**East West Rail Network Phase 2 The Scheme  
Railway From London Road Bicester To Station  
Road Launton**

**20/03365/DISC**

**Proposal:** Discharge of condition 7 (a)(b)(ii) (landscaping proposals at Bridge 34A Station Road) of 18/01430/TWAO

CONTINUED ON DRAWING 133735 2B-EWR-OXD-XX-DR-L-011209

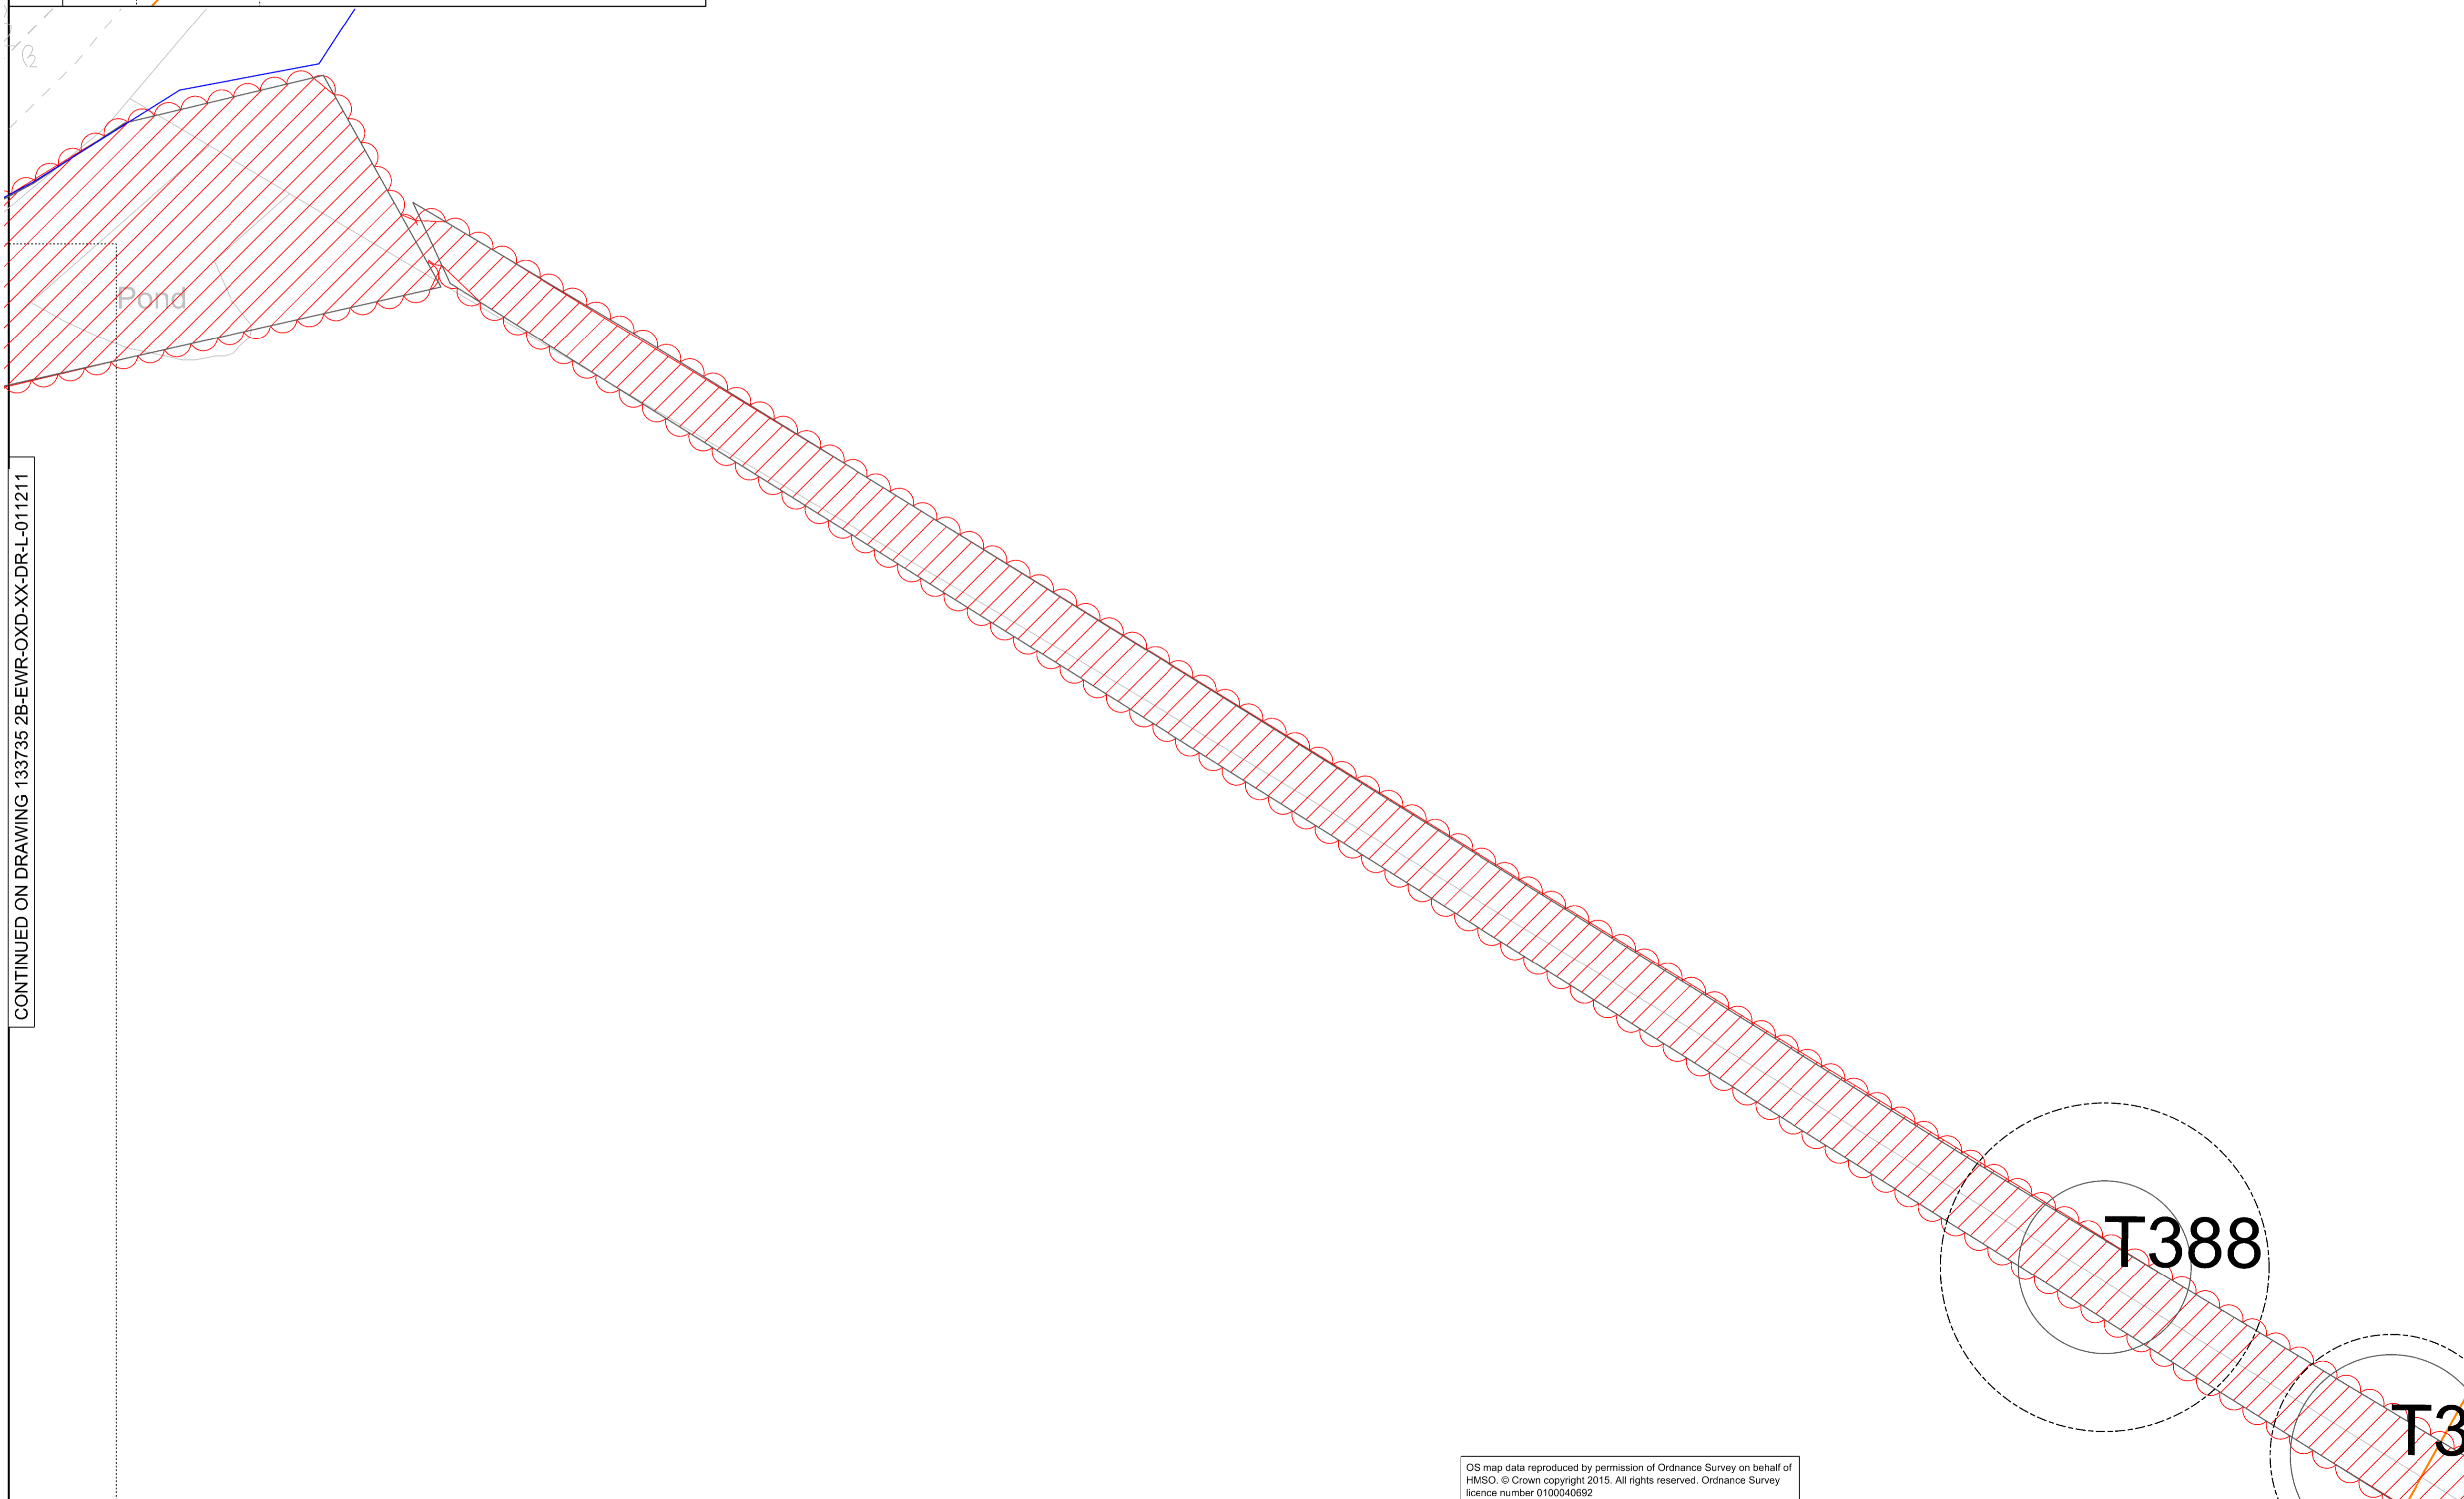
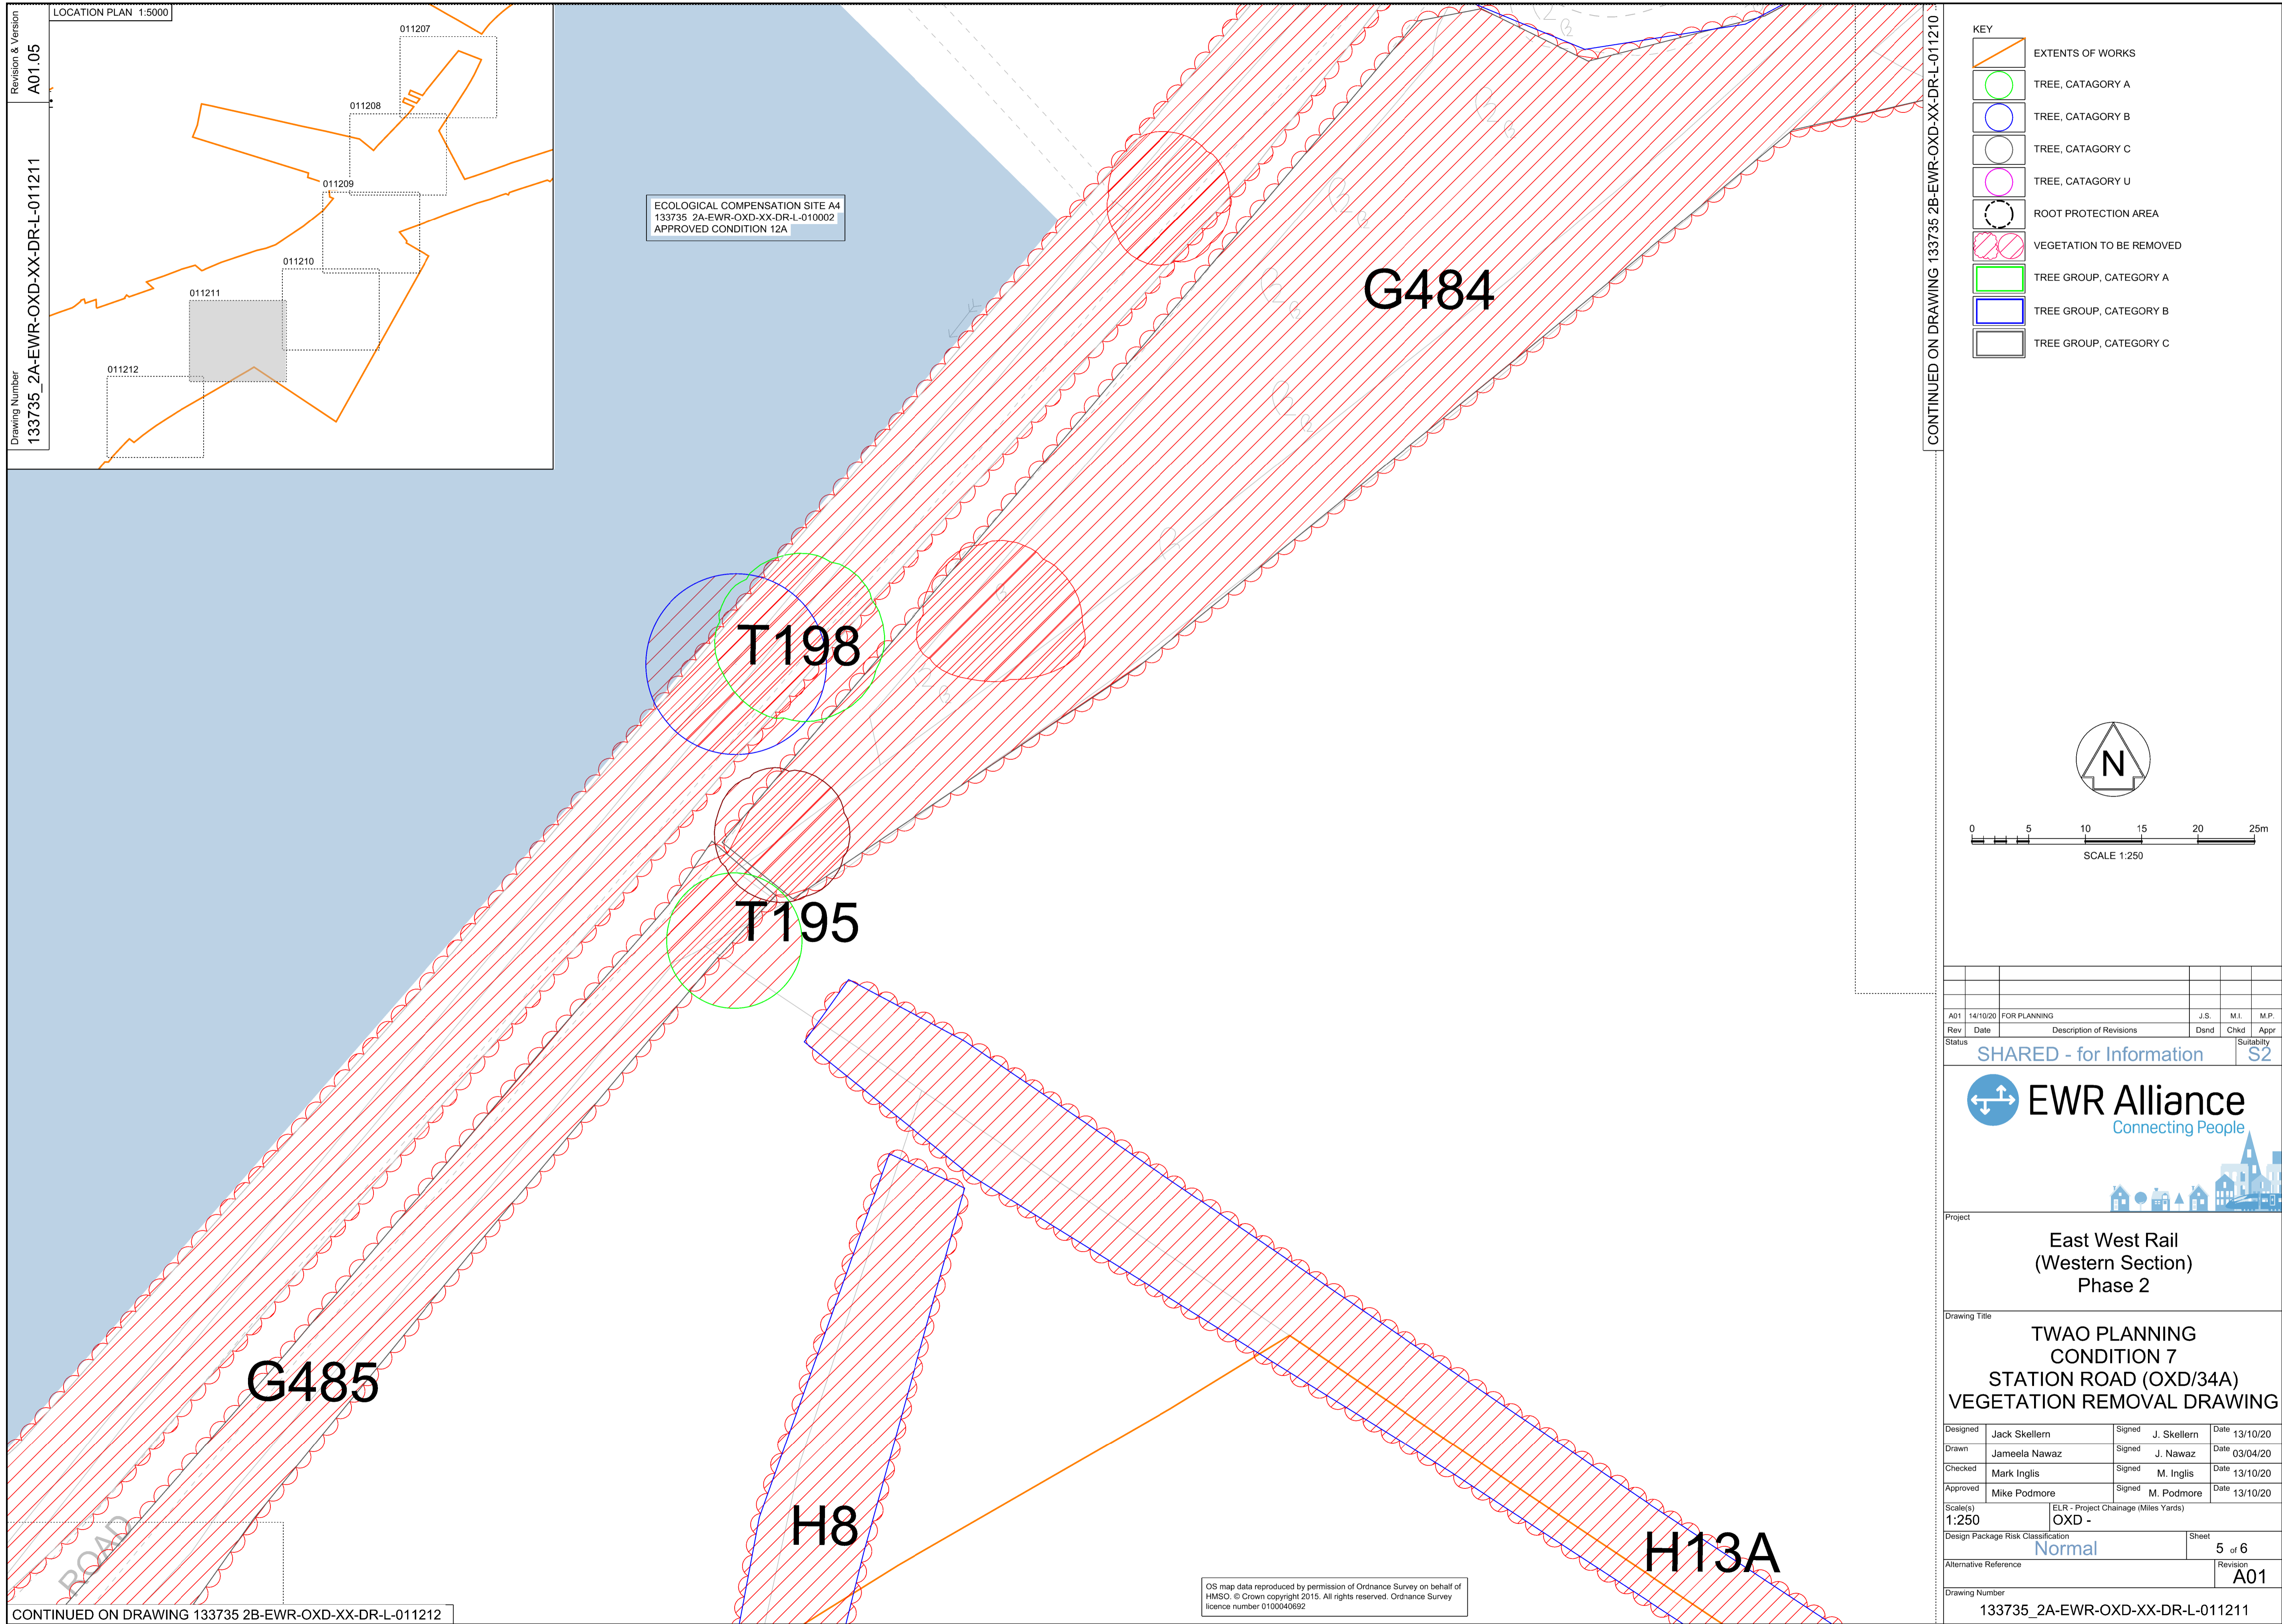
4.1 CDC Landscape Officer – I still have concerns about the extensive loss of established vegetation to facilitate this railway. Is there any compensatory measures included? How is the East West Rail Alliance going to improve the situation with additional native tree and shrub planting? The written specification appears to be fine.

5.1 The application has been assessed by the Council's Landscape Officer and his comments above were forwarded in December 2020 to the applicant for further consideration of the submission. A response from the applicant was received in March 2021 advising that compensation for the loss of vegetation would be provided along the whole of the network corridor and in addition ahead of the works, 19 ecological compensation sites have already been provided and in many cases are now becoming established.

- 5.2 Having regard to the above comments, it is considered on balance that whilst the loss of vegetation at this particular area is regrettable, that overall, the scheme delivers adequate compensation planting and landscaping elsewhere. The application is therefore recommended for discharge accordingly.
- 5.3 The original application was EIA development. The application submission seeks to deliver the landscaping scheme as set out in the original submission and has no additional impacts above those already considered in the original ES. Therefore, the EIA is considered sufficient for the purpose of considering the information provided for this condition and it has been taken into account in considering this subsequent application.
